Development Facilitation Team (DFT) – Review Comments

Project No: PR-2023-009527 Date: 02/28/2024 Agenda Item: #1 Zone Atlas Page: G-12

Application For: SD-2024-00030 – VACATION OF PUBLIC RIGHT-OF-WAY

Application For: SD-2024-00029 – PRELIMINARY/FINAL PLAT

PLAT OF
**LOT B-3-A, ALVARADO
 GARDENS UNIT 2**

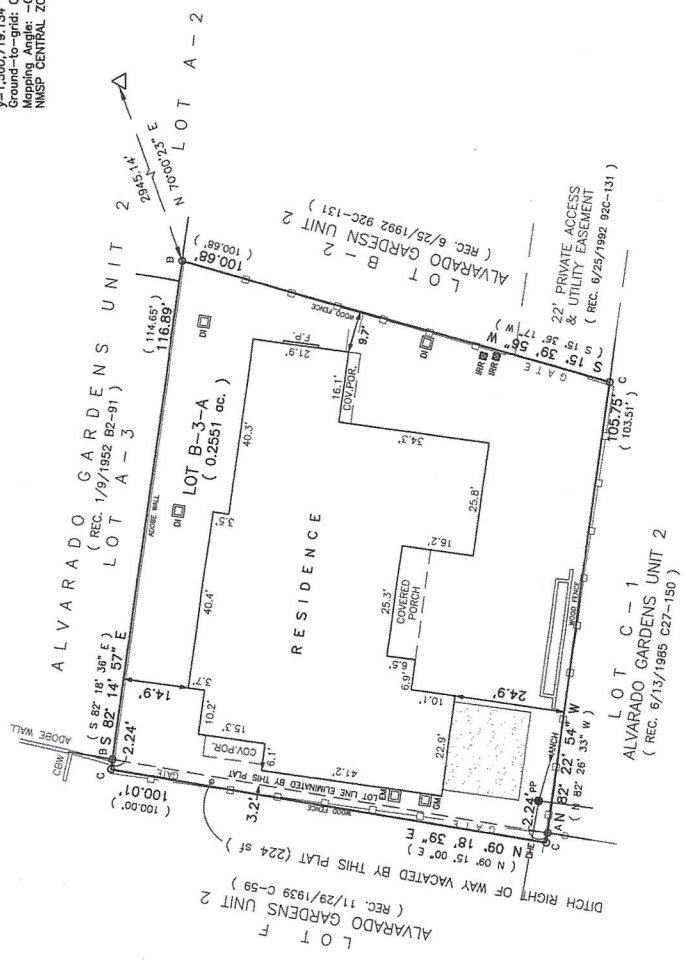
- **Application number** needs to be added to the Plat.
- Prior to final sign-off of the plat, the AGIS office must approve the DXF file and proof of approval must be provided.
- Per MRGCD request, if the DHO approves this application, provide a note on the plat that the vacation of easement or public right of way was approved per vacation ordinance 6-6 (M)(3).

**Ditch R.O.W
 Exhibit**

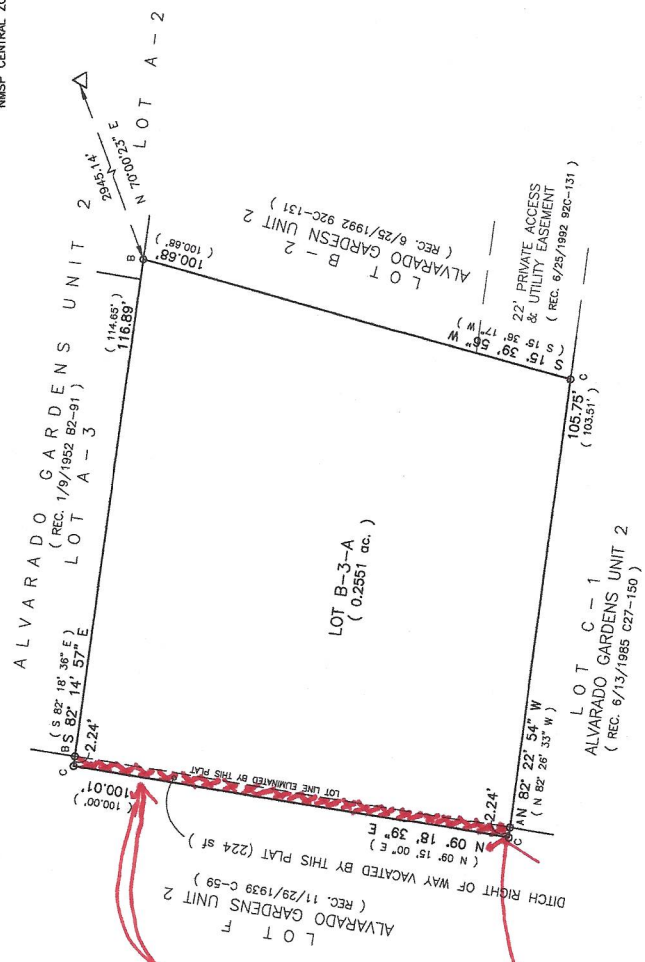
- Please *clarify the reason* for vacating part of the ditch to incorporate into the subject property.
- Planning staff suggest that at least half of the ditch easement be vacated per this application. Please confirm whether or not the applicant has coordinated with neighbor at 2438 Campbell Rd NW in regards to this vacation of easement.

- In case the applicant decides to vacate the entire width of the ditch, this application needs to go before the City Council – the DHO in that case shall make a recommendation and forward the application to City Council for inclusion on the consent agenda for approval without first going to any City Council committee per 6-6(M)(2)(f) of the IDO.
